Application number: 2024/93047	
What is the application for?:	Conversion of garage to living space with new windows and door (Listed Building
Address of the site or building:	65B, Westgate, Almondbury, Huddersfield, HD5 8XF
Postcode:	HD5 8XF

Project Proposed change of use of garage to bedroom.		
For Miss J Emmett.		
Address 65 B Westgate Almondbury HD5 8XF.		
Title Existing layouts and elevations.		
Job No. 24 J 33.	Drawing number 01 A.	Date Sept 2024.

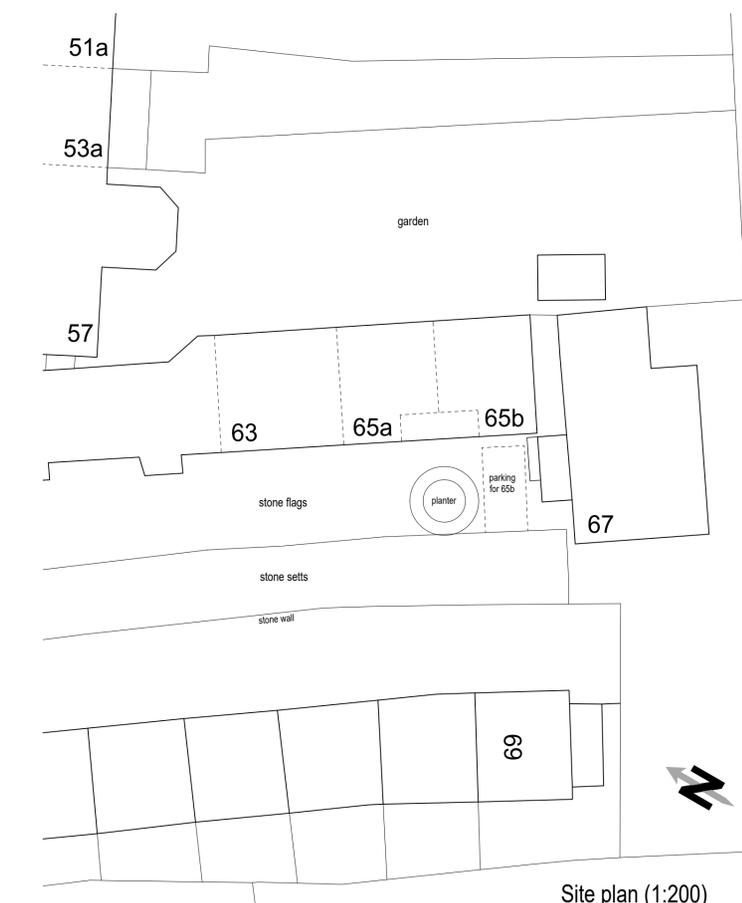
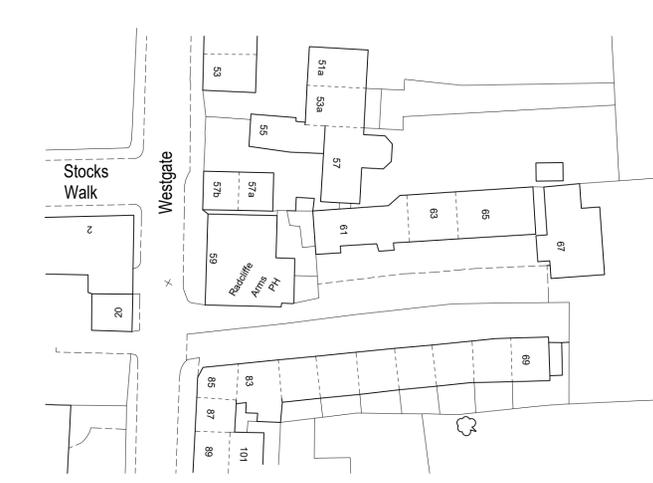
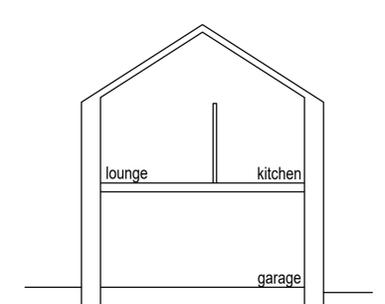
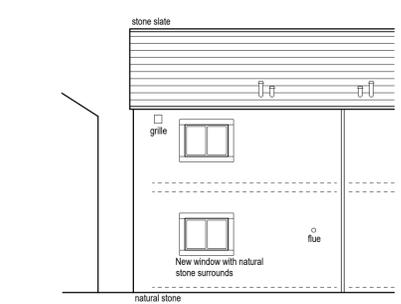
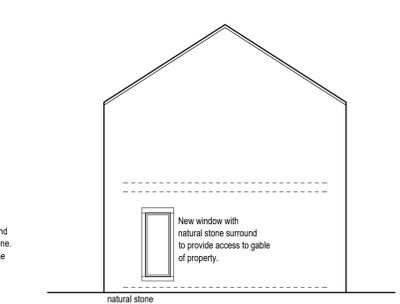
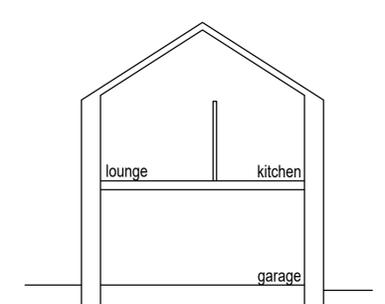
Type of comment: An objection	
Do you wish your comments to be published on the website anonymously?	Yes
<p>This property backs on to the private garden of another property. 65B does not currently have external access to the rear of the property, or any land behind it, meaning the door would open in to another garden, spoiling the peaceful enjoyment of the garden for the owner and significantly reducing their ability to utilise their space. The additional windows will also encroach on the privacy of the garden, affecting their wellbeing.</p>
